Re: Serenity Amenity

This department is reviewing the plan you submitted for the Serenity Amenity swimming pool to be constructed at 325 Streamside Terrace, Fuquay Varina. This plan review is being conducted in accordance with the current North Carolina Rules Governing Public Swimming Pools (15A NCAC 18A .2500).

**REC BLDG POOL RESTROOMS**

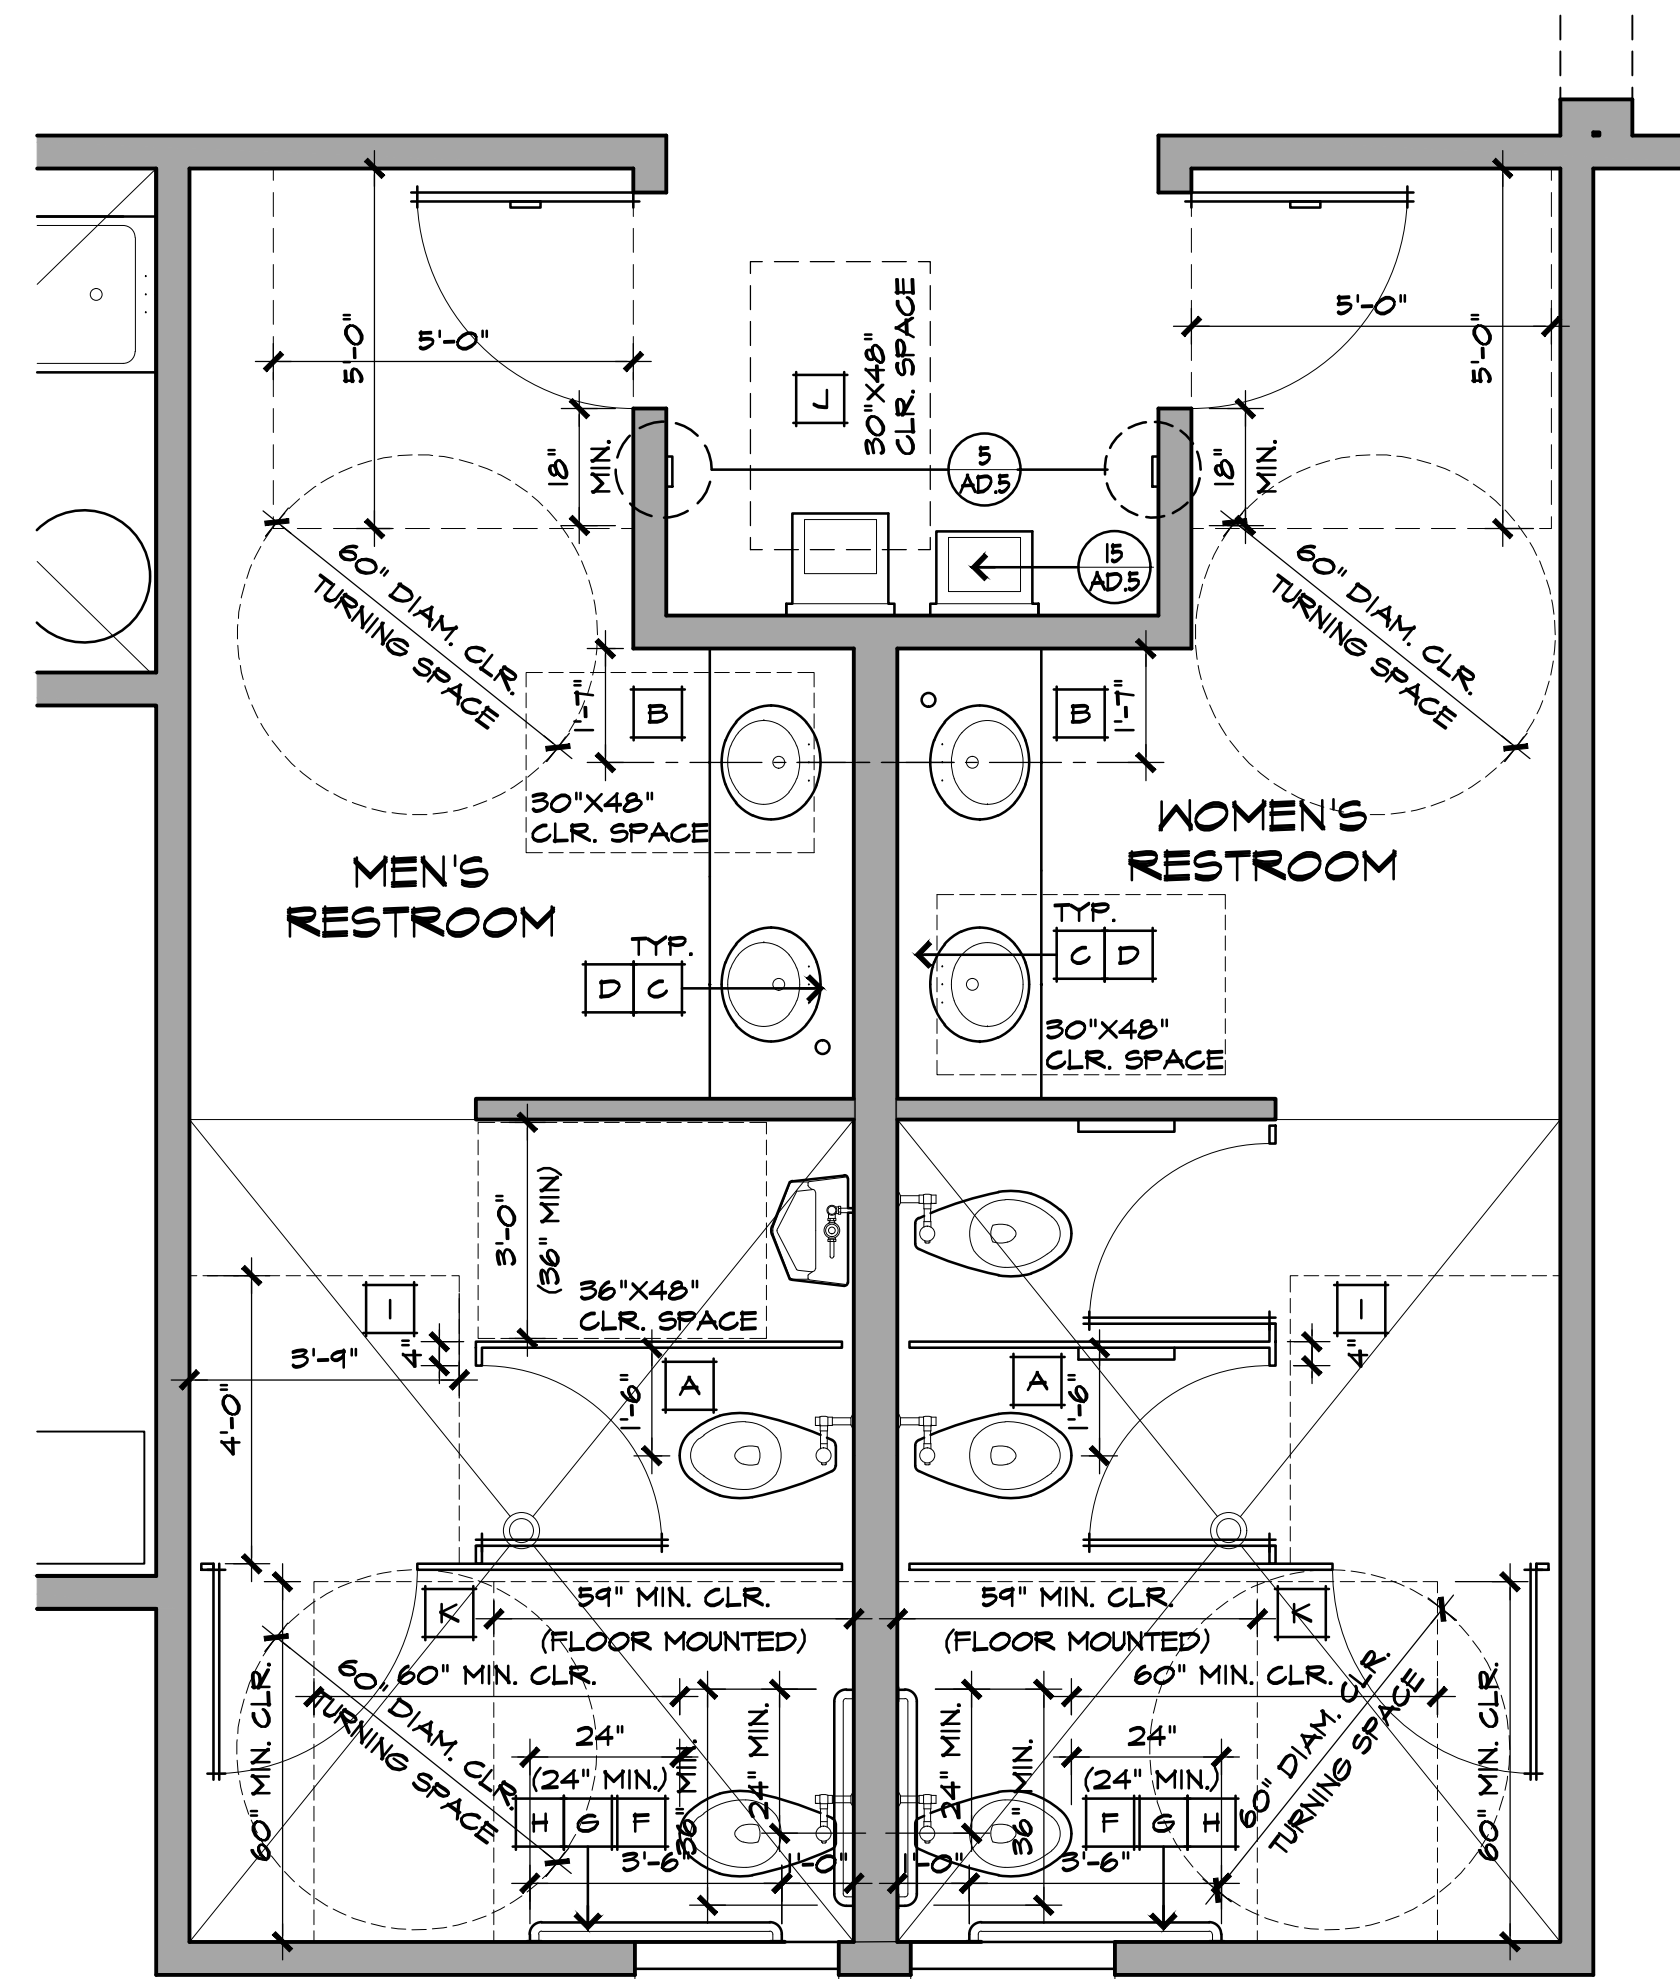
- Tile in restrooms is listed as ceramic and/or porcelain. Provide further information as to whether the tile is slip resistant.
- Clarify whether there are ANY doors or windows that will open directly from an occupied building onto the pool deck.
